CITY OF ALBUQUERQUE

**Re: Lot 10 Block 9 Unit 22 Volcano Cliffs, S.A.D. 228
6401 Petirrojo Rd. NW
Request Permanent C.O. – Not Accepted
Engineer's Stamp dated: 4-11-17 (D10D003Q101)
Certification dated: Not Provided**

Based on the Certification received 10/23/2017, the site cannot be accepted for release of Certificate of Occupancy by Hydrology until the following comments are addressed.

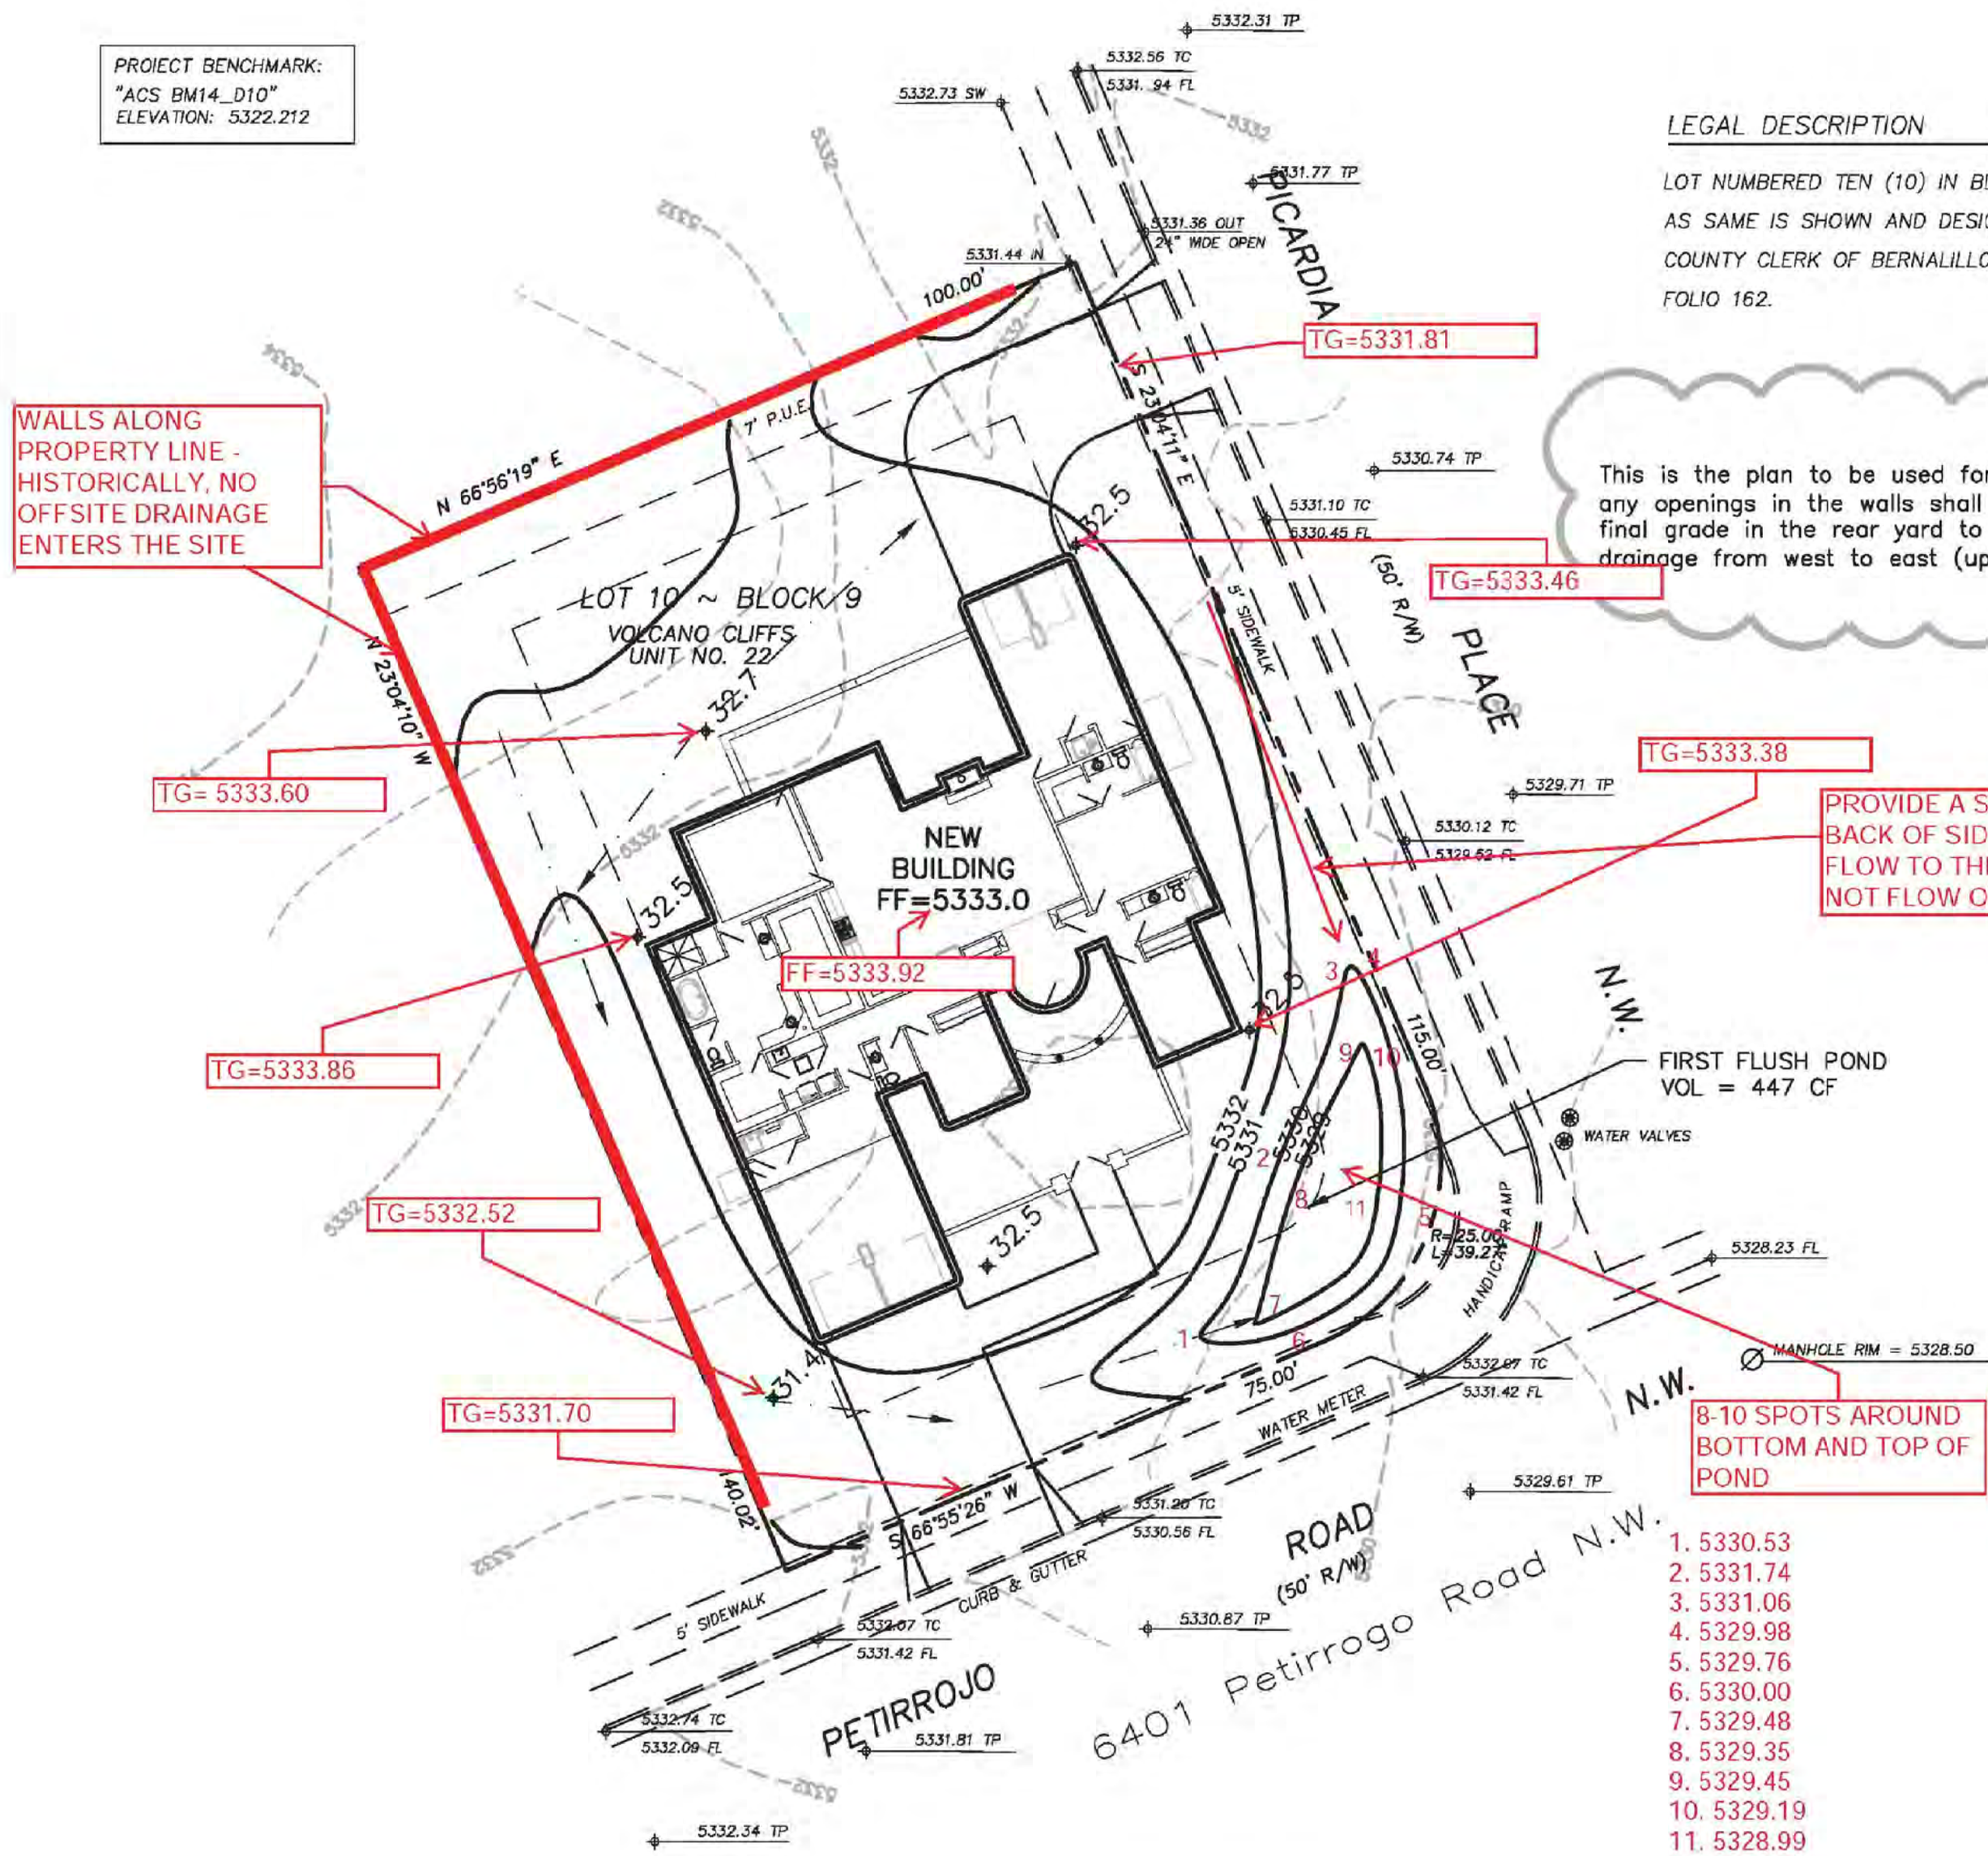
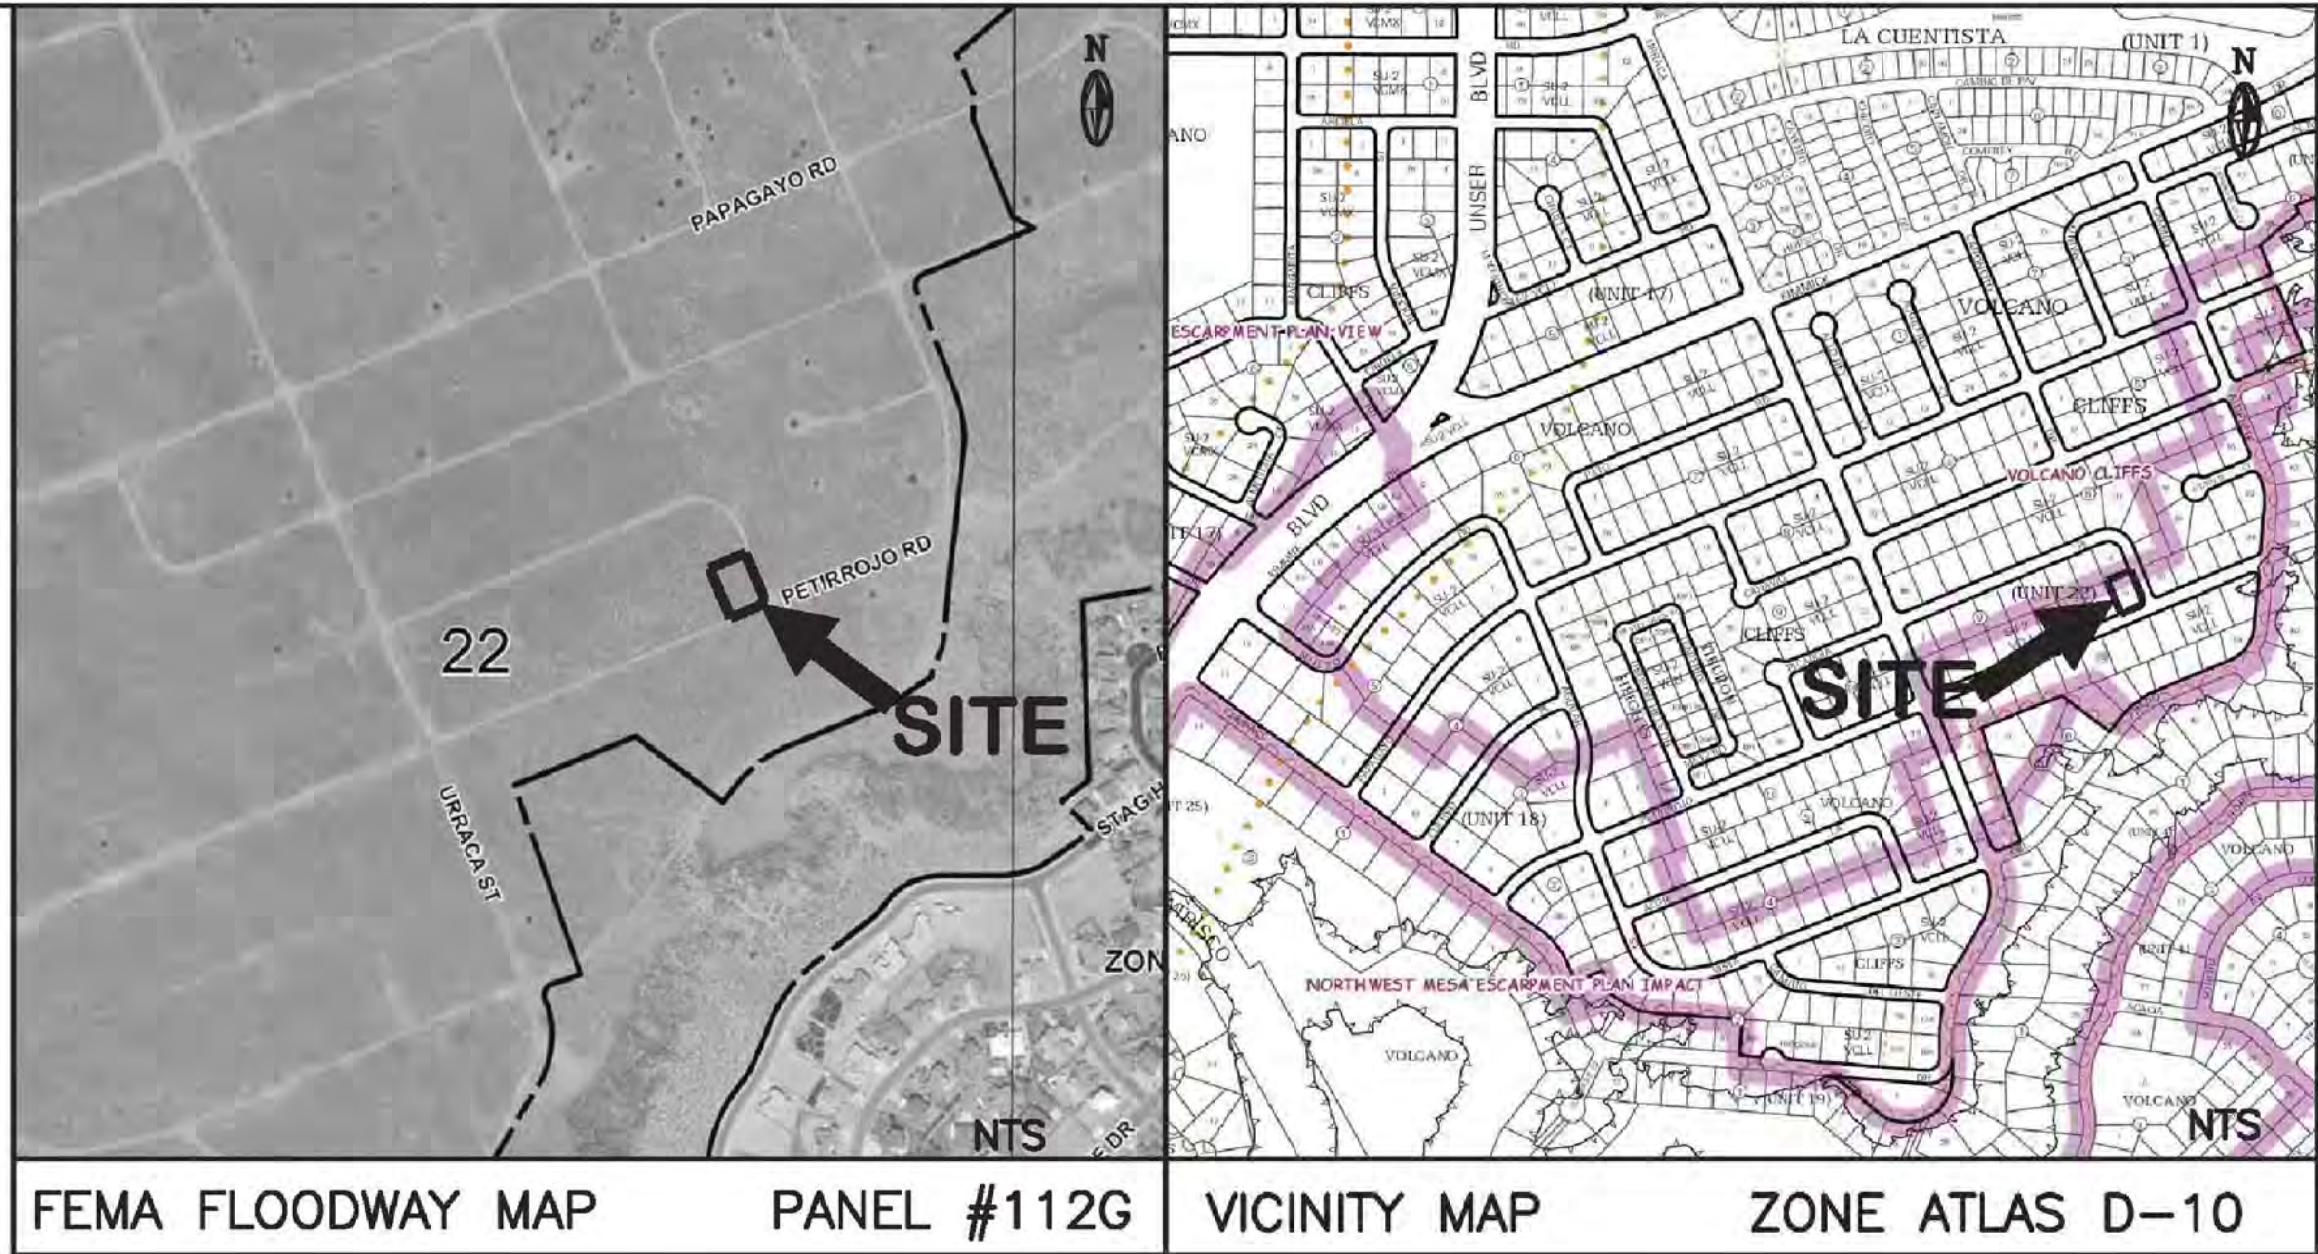
- Provide the Certificate of Occupancy statement on the plan.
